**Appendix B to the Relevant Representations of Natural England**  
**Marine Geology, Oceanography and Physical Processes**

The construction and operation of the Five Estuaries Offshore Wind Farm located approximately 57km from the Essex Coast in the Southern North Sea.

Planning Inspectorate Reference EN010115

13 August 2024

Figure 12. Comparison of measured and modelled (SEASTATES hindcast) wave parameters at location West Gabbard wave buoy

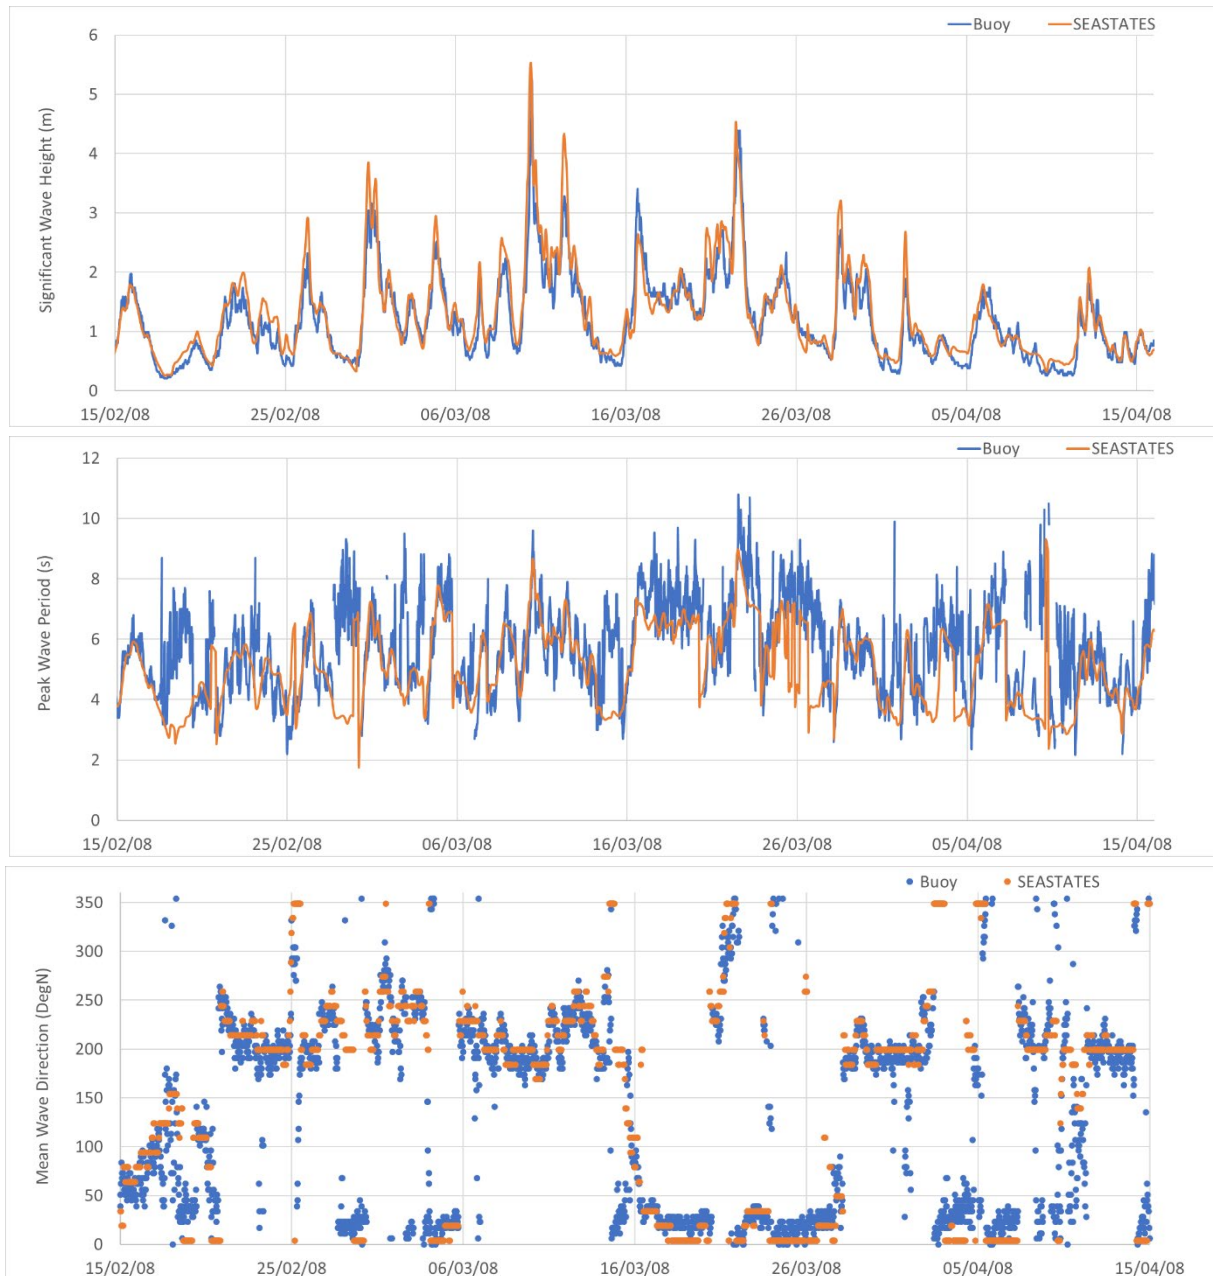
Natural England's Key Considerations	Natural England's Advice				
Relevant and Written Representations	NE Ref	Ref	Comment	Recommendation	Risk (RAG)
			Figure 12 shows that SEASTATES hindcast slightly overpredicts some of the significant wave height peaks, but the modelled peak wave period appears to underpredict measured peak wave period for approx. 25% of the time series shown.	Applicant and their consultants, because it does not align with best practice. However, unless there are significant changes to the project design and/or mitigation measures cannot be delivered, we do not believe that updating the modelling and/or assessment would make a material difference to the predicted project impacts as this time.	
<b>Environmental Impact Assessment - Document Used:</b> [APP-040] 5.4 Report to Inform Appropriate Assessment, [APP-069] 6.2.1 Offshore Project Description, [APP-071] 6.2.2 Chapter 2: Marine Geology, Oceanography and Physical Processes, [APP-101] 6.5.2.3 Annex 2.3: Physical Processes Technical Assessment, [APP-083] 6.3.1 Onshore Project Description, [APP-261] 9.28 Outline Landfall Methodology, [APP-264] 9.31 Schedule of Mitigation Routemap, [APP-081] 6.2.12 Infrastructure and Other Marine Users, [APP-099] 6.5.2.1 ES Annex Physical Processes Baseline Technical Report, [APP-097] 6.5.2.2 ES Annex Physical Processes Model Design and Validation.
